Our Case Number: ABP-310286-21

Re: Railway works and all works necessary to eliminate and, where necessary, upgrade seven numbered level crossings and carry out all associated and ancillary works along a 24-kilometre section of the Dublin to Cork Railway Line.
Fantstown, Thomastown, Ballyhay, Newtown, Ballycoskery (Ballyhea Village), Shinanagh and Buttevant, Co. Cork and Co. Limerick.

EFFIN G.A.A CLUB

Re: Railway Bridge, Lower Effin, County Limerick

Figure 2.5: XC201 Thomastown Proposed Route Alignment

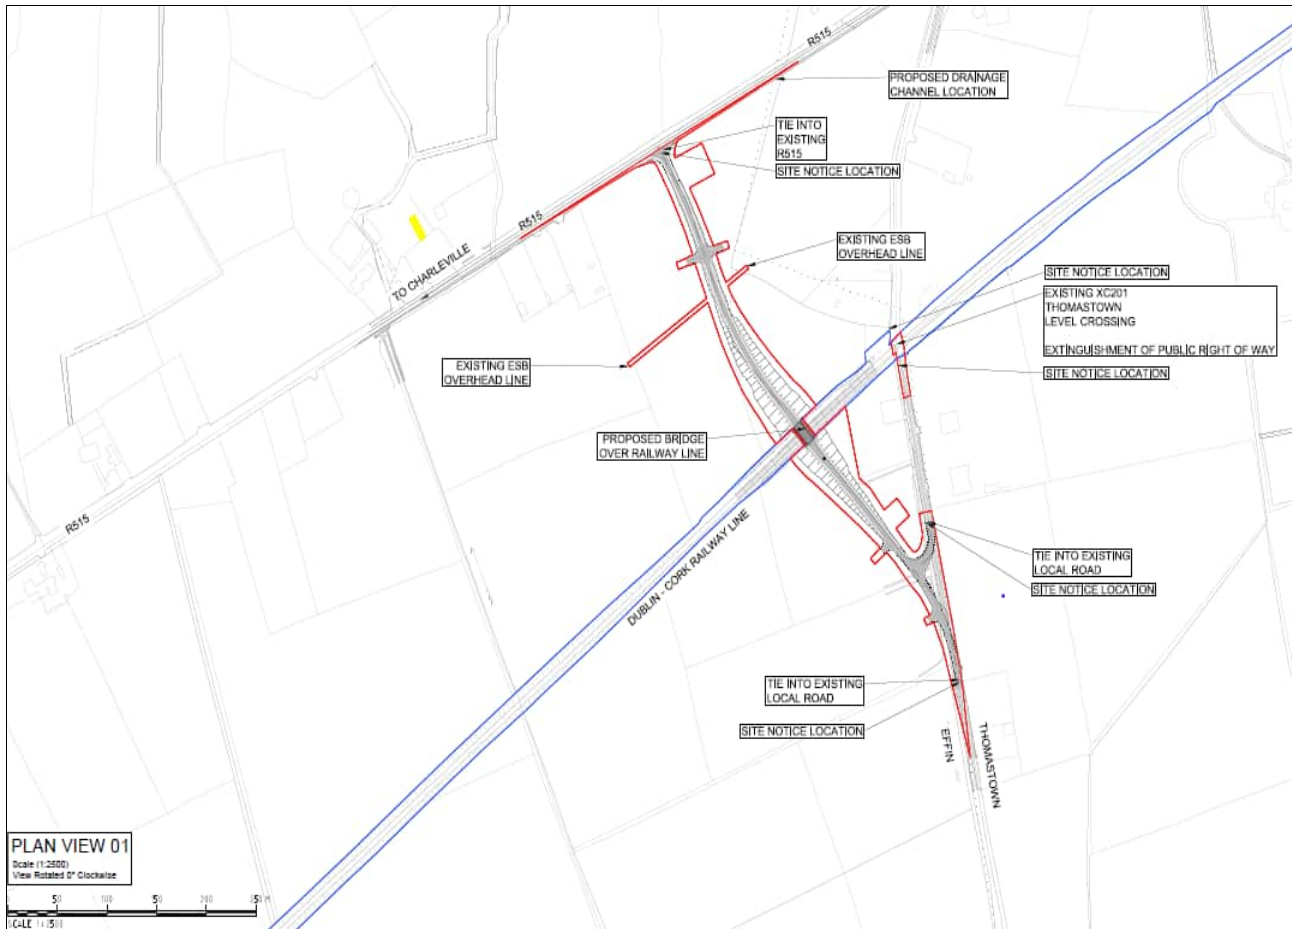
Over the last 100 years the railway has restricted our club as we loose out to other clubs. However, looking at the plans we see that the new development is only a single lane road.

We believe that this will still restrict access to our club and a double lane road is the only safe solution, and a safe new junction layout where the new road meets the R515.
